4 November 2020

**RE: Notice of Exhibition – Modification Request 2 Catherine Field Primary School (SSD 9477)**

**PROPERTY: O'Keefe Drive ORAN PARK  
LOT: 1001 DP: 1234527**

**Figure 2** SSD-9477 Extract of proposed modified site plan showing car park and DOPUZ (Source: Perumal Pedavoli, 17/09/20)

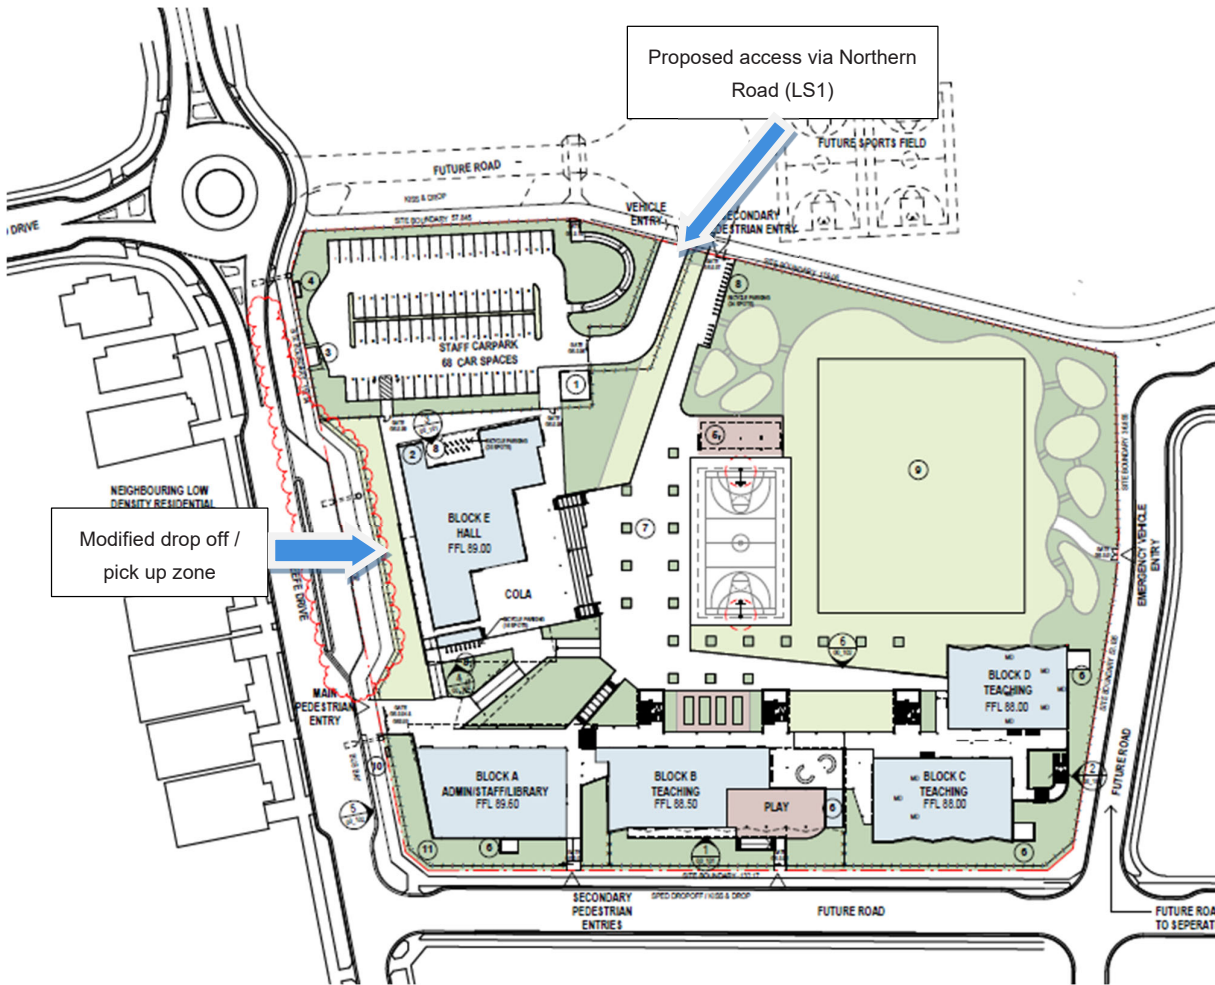
It is noted that the Site Layout Plan requires access through a future Council reserve known as LS1. Although this cul-de-sac is shown as a road in the submitted plans currently it is only proposed to be a driveway access within Council land. As such the Department of Education will be required to negotiate terms for a right of carriageway or dedication of the land as public road in order to obtain lawful access prior to the decommissioning of interim site layout plan (access via O'Keefe Drive). Camden Council requests a condition of consent be imposed similar to the following:

*Suitable arrangements are to be agreed and enacted with Camden Council relating to the use of the future public reserve known as LS1 for vehicular access to the school's carpark. These arrangements shall be agreed and enacted prior to the connection of the school's carpark to the 4<sup>th</sup> leg of the Banfield Drive / O'Keefe Drive roundabout via the LS1 access driveway and prior to the decommissioning of the interim car park access directly to/from O'Keefe Drive, if constructed.*

Figure 3 Site Plan – Temporary Car Park Access (Source: Perumal Pedavoli, September 2020)

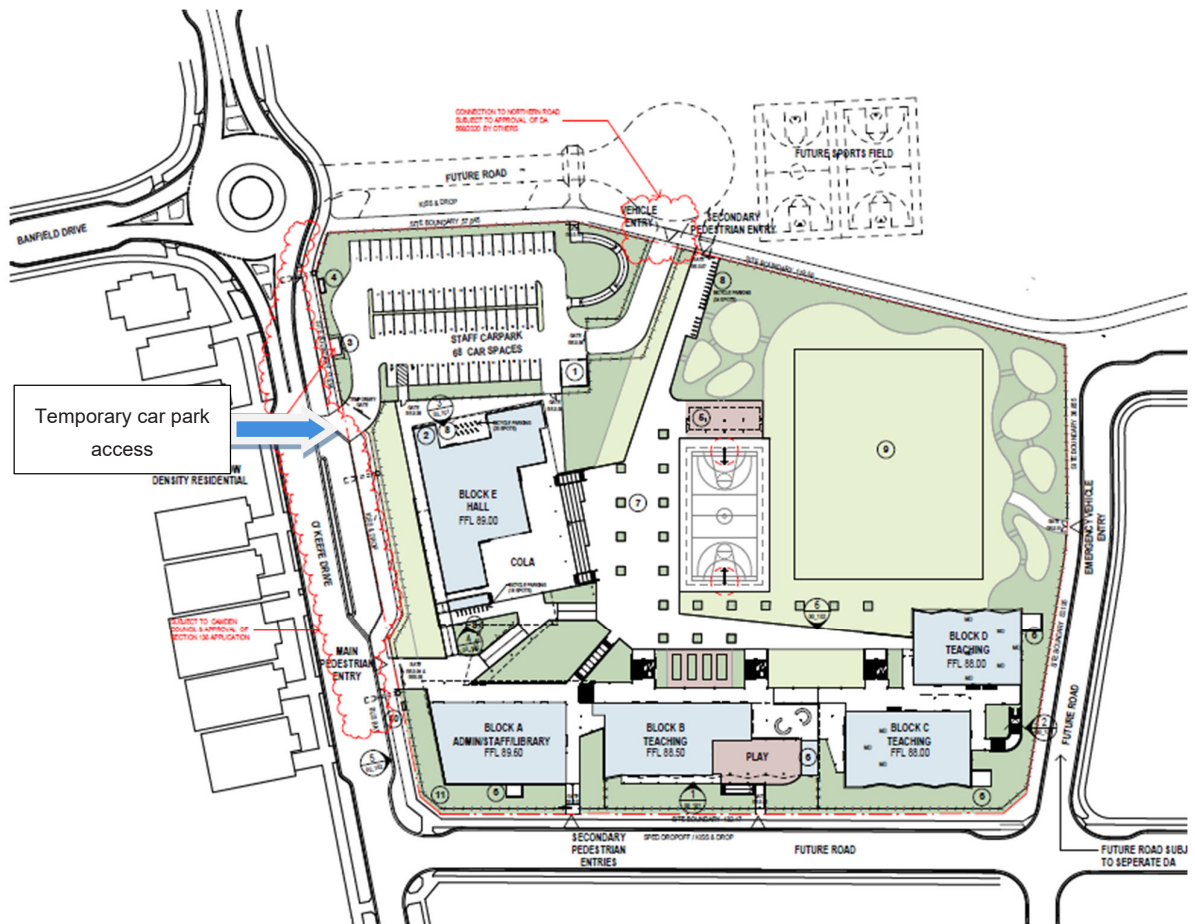
The revised car park layout is supported by Council. The interim layout is also supported subject to the following comments on the access/egress point on O'Keefe Drive for the Department's consideration:

- Swept paths shall be submitted showing vehicles entering and exiting the interim car park access;

- Sightlines at the interim access shall be assessed – the driveway is angled and setback, also it's not clear if trees will be planted adjacent to the driveway;
- Queuing at the Kiss and drop area may obstruct the interim driveway particularly during pick-up and drop off periods;
- Local Traffic committee concurrence is required for the required signage and line marking – disabled parking should be considered;

The detailed design, line marking and signage considerations can be dealt with through the Roads Act Application and Local Traffic Committee processes. It is noted that existing condition B26 already requires the approval of a Roads Act application by Council as the relevant roads authority. However, there are no conditions which require approval of the signage and line marking changes by the Local Traffic Committee. As such it is requested that the following Camden Council standard condition be added to the consent:

*Installation of or changes to regulatory signage, line marking and devices are subject to the concurrence of Camden Council's Local Traffic Committee on local roads and Transport for NSW on State roads. These concurrences (as required) must be obtained prior to the installation of or any changes to regulatory signage, line marking and devices.*

DRAWING NAME
LANDSCAPE: SITE FINISHES PLAN

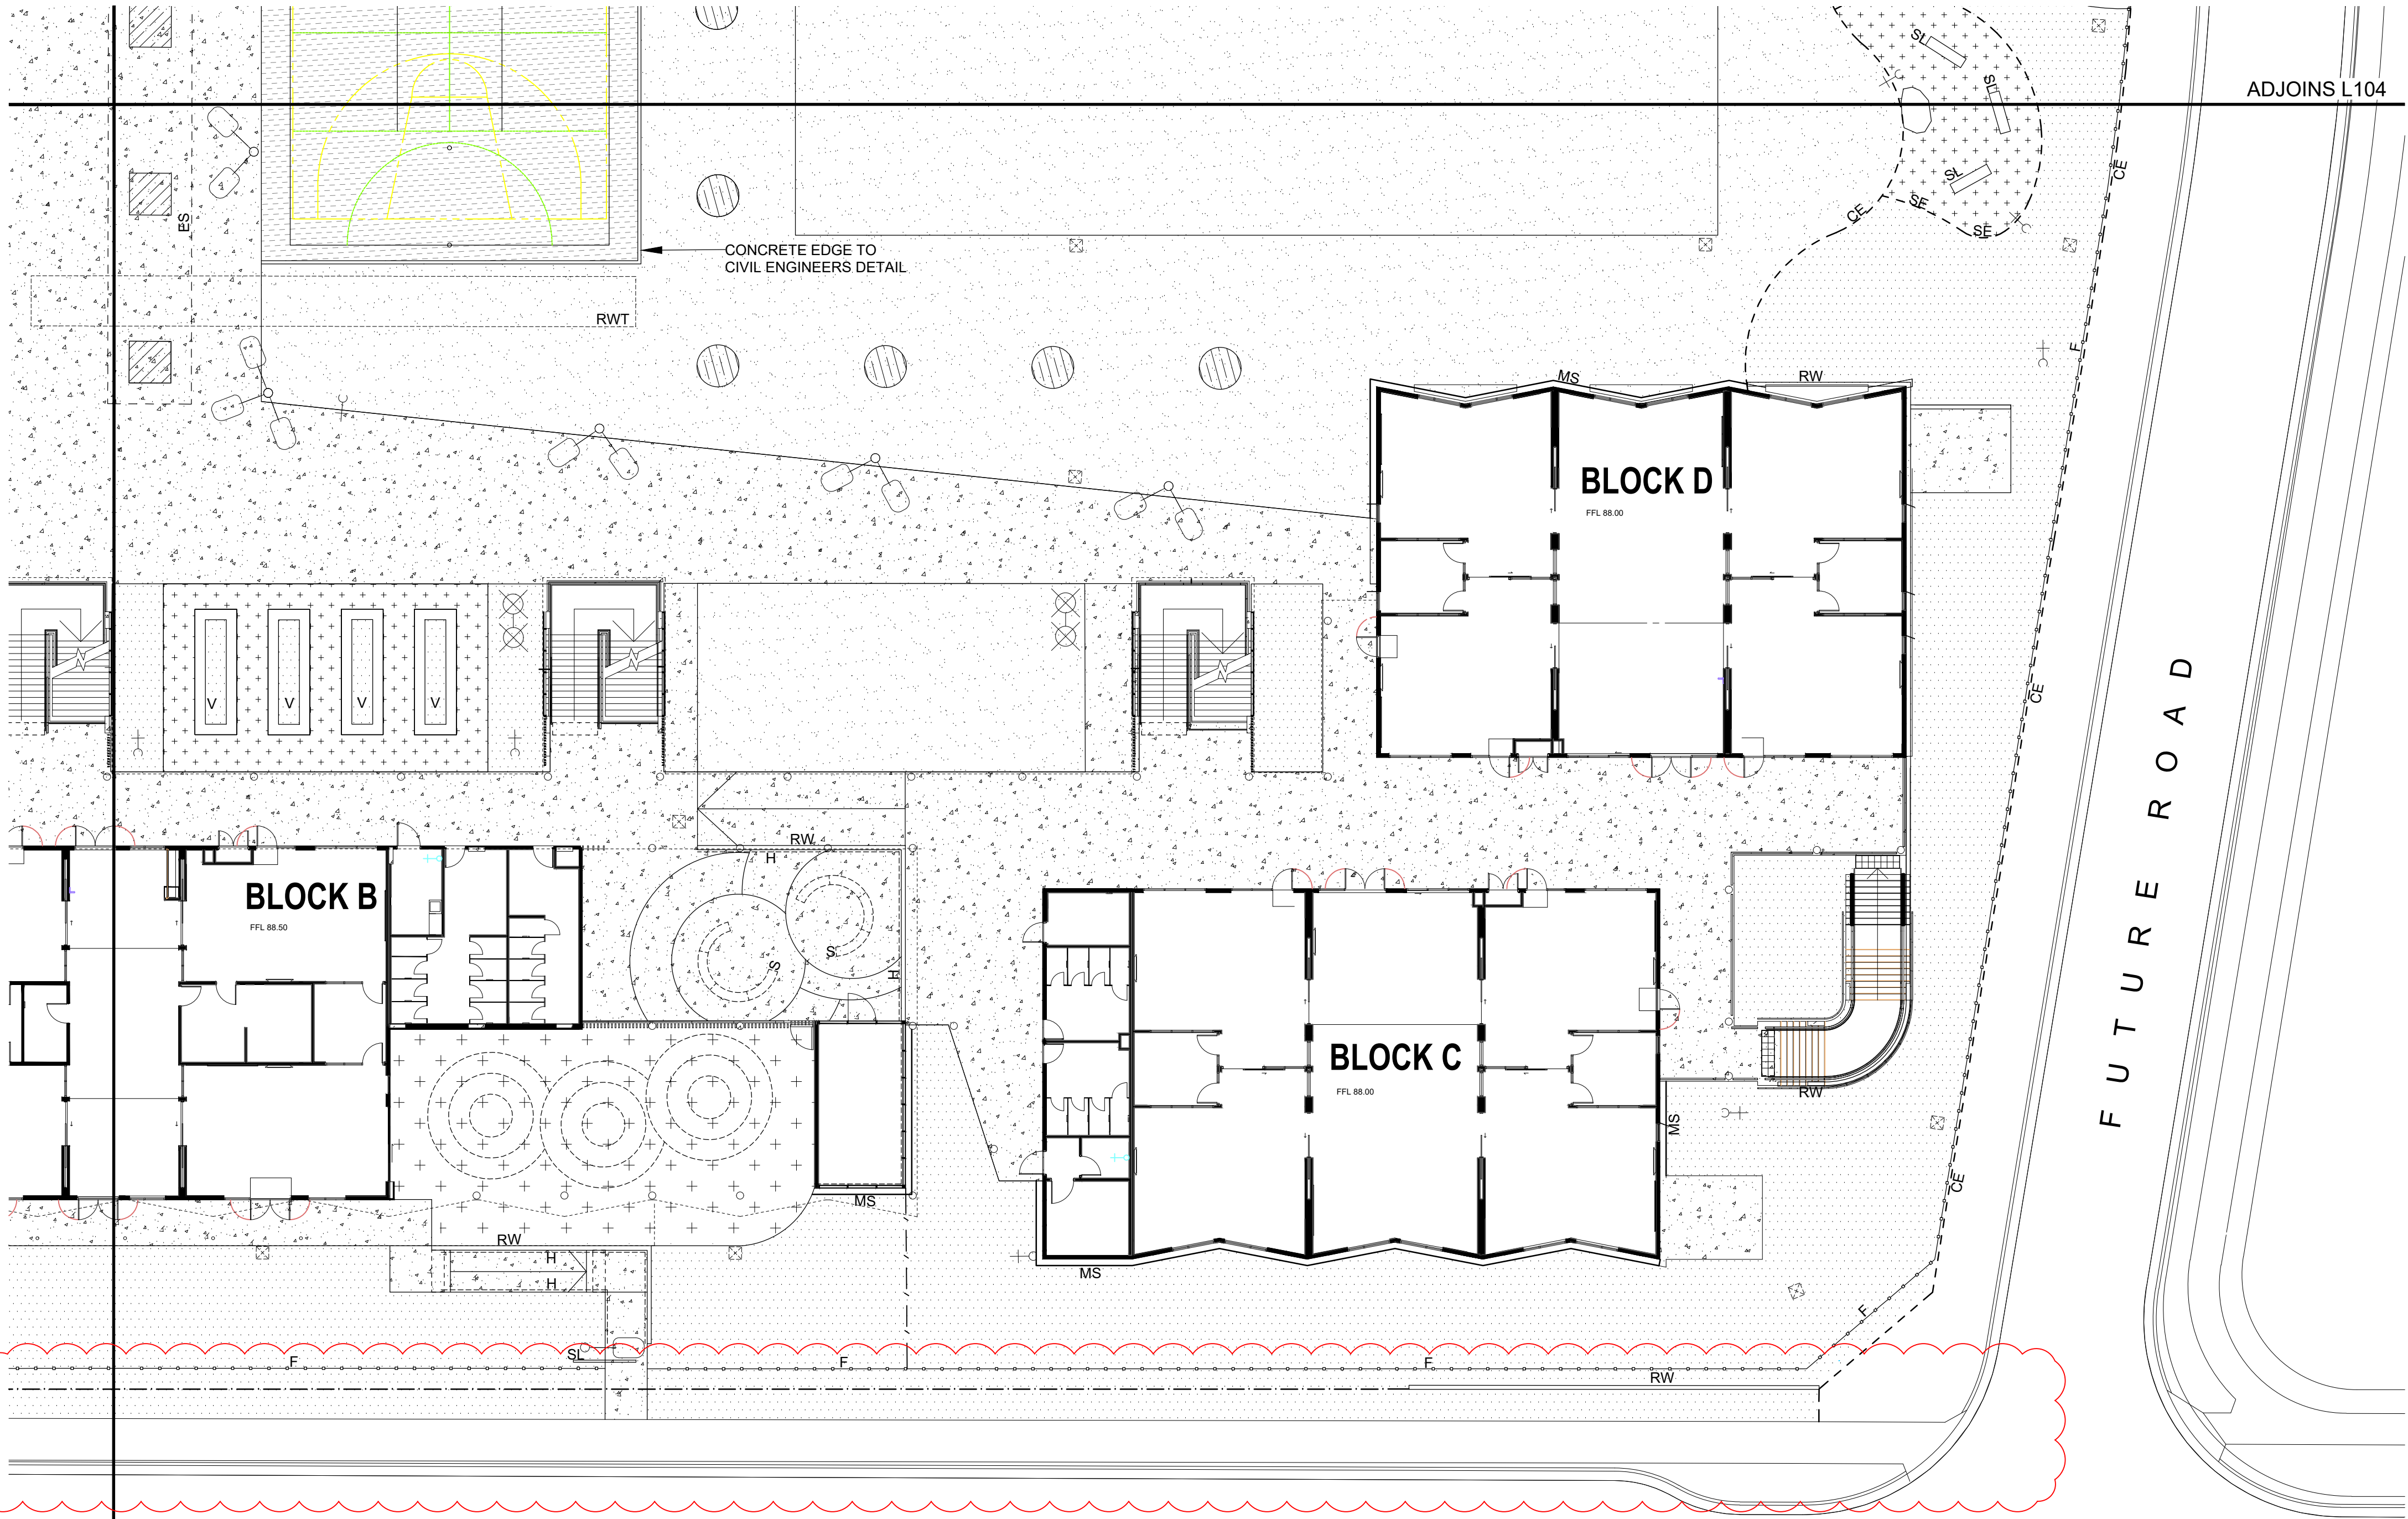
The landscape plans submitted with the application show the removal of all street trees along O'Keefe Drive and no street trees along the southern perimeter road. There appears to be ample opportunity to plant street trees in the unencumbered areas of these road verges. Street trees should be avoided near the entrance and exit of the kiss and drop / interim car park to avoid blocking sight lines.
